ATTACHMENT 1

In order to finalise the Department's assessment, additional information is required including but not limited to the following:

PODIUM SLAB PLAN
Scale 1:500

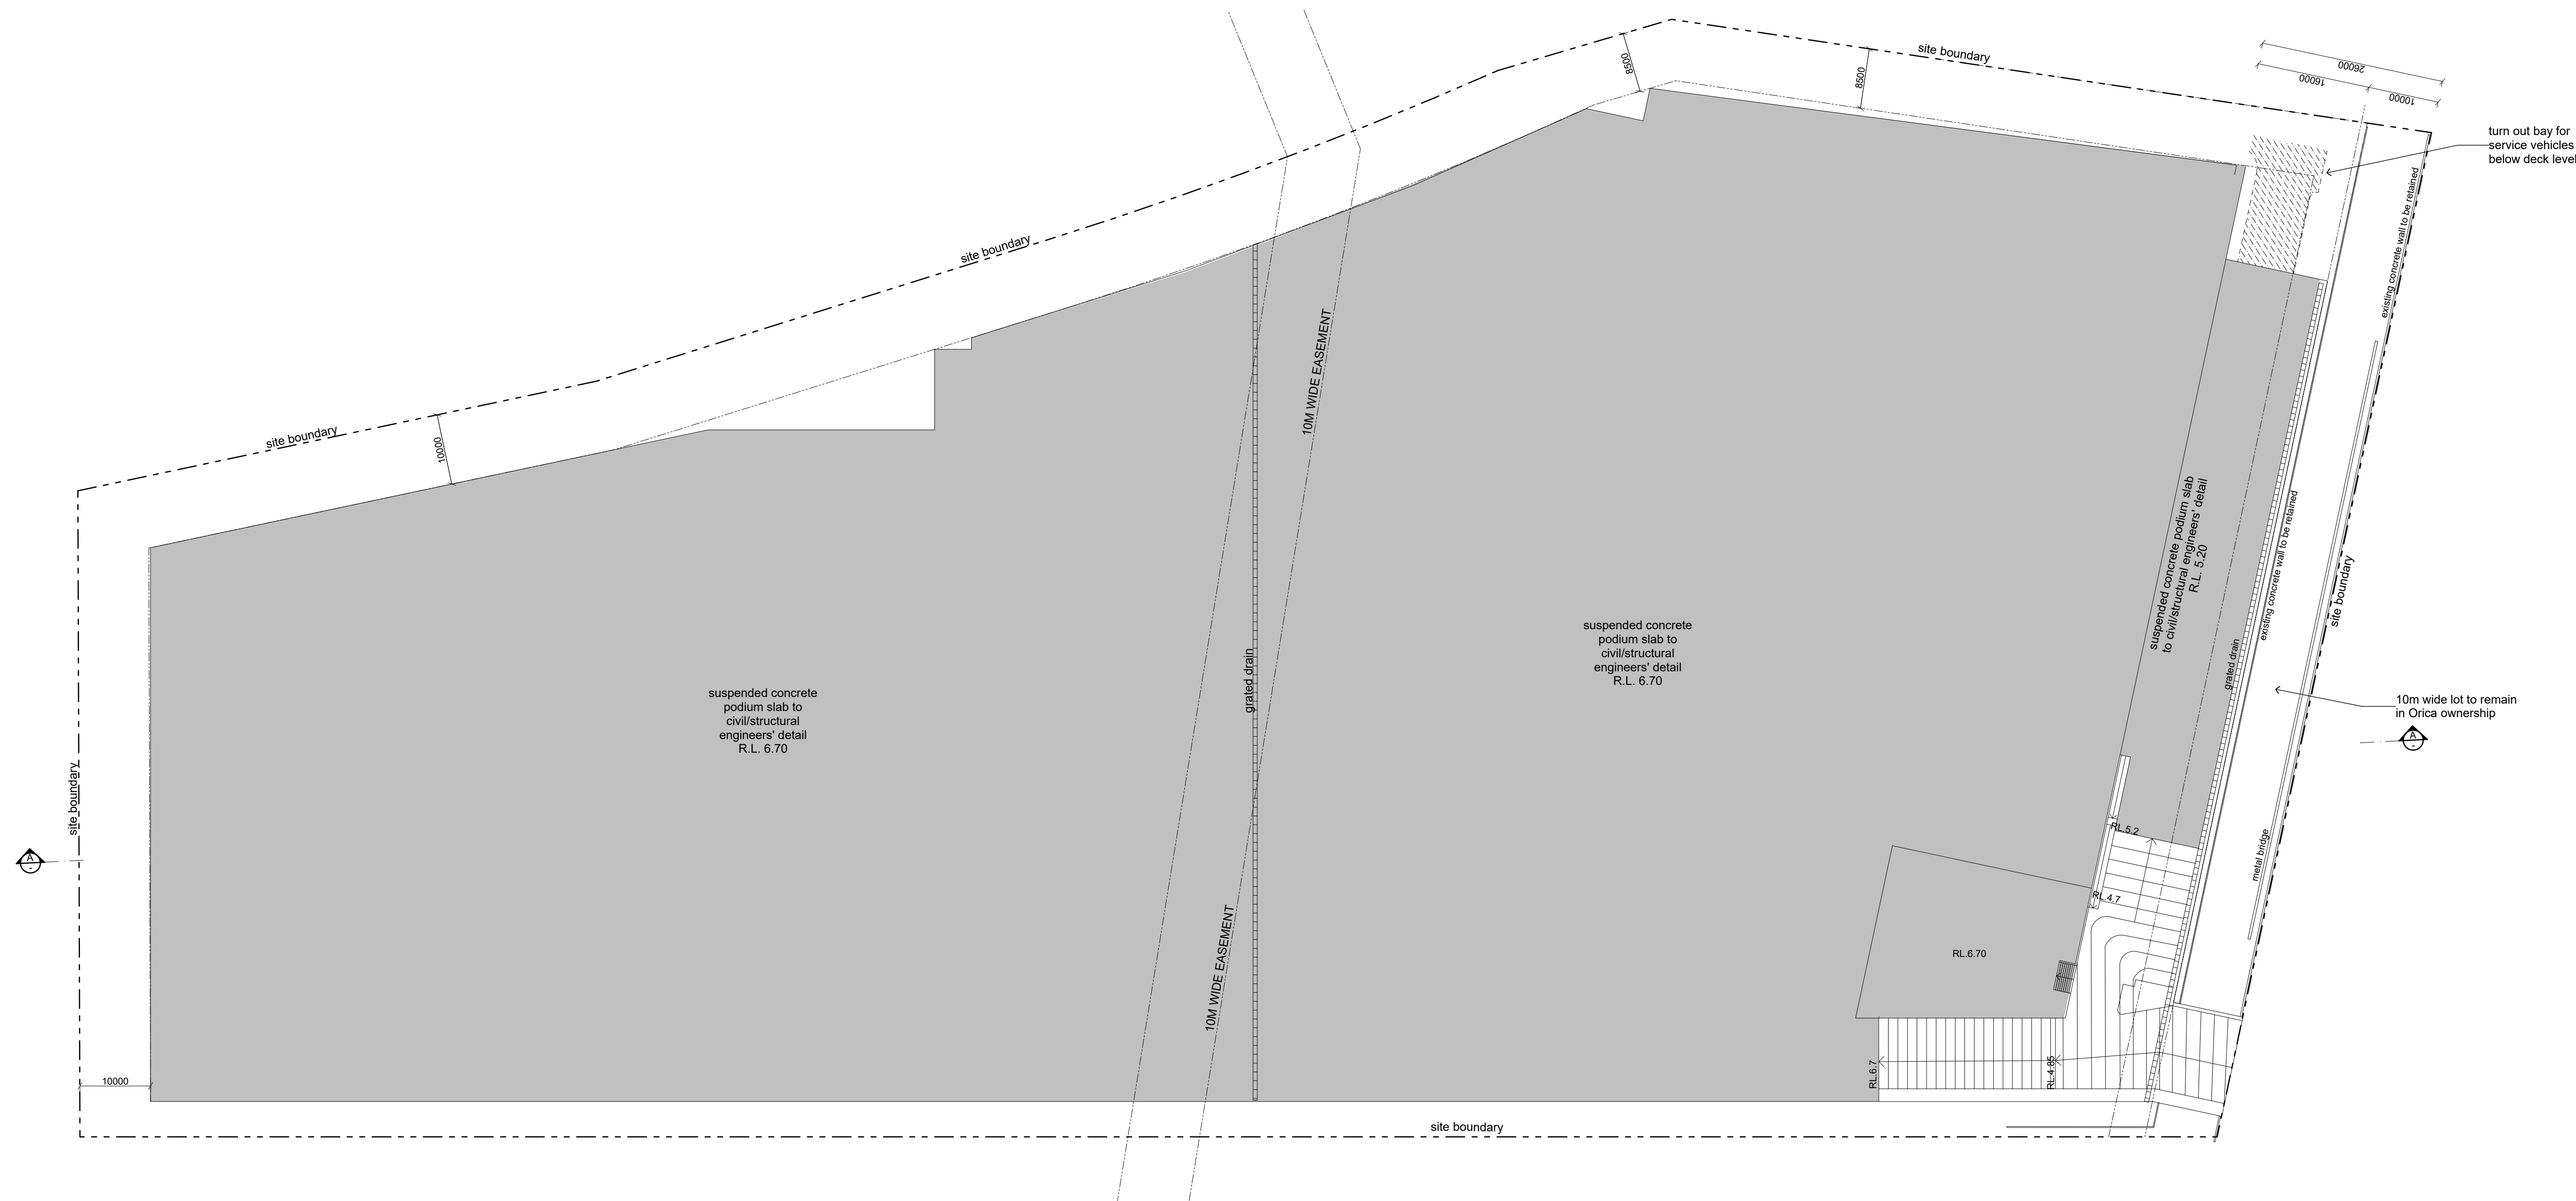
- Clarification is required whether the Flood Impact Assessment has considered the impacts on flooding of the proposed barrier/capping layer across the site and the implications of the flood detention basin being permanently covered by the proposed concrete platform.
- The Department notes the comments from Randwick City Council regarding the potential for the proposed development to reduce the volume of the flood detention basin on site and requests further details in this regard.
- Further details are required as to which surrounding lands rely on the site as a flood detention basin.
- It is requested the Applicant provide details of other developments that have adopted a similar built form design response within a flood detention basin and provide details on how the impacts of that design on the function of the basin were mitigated.
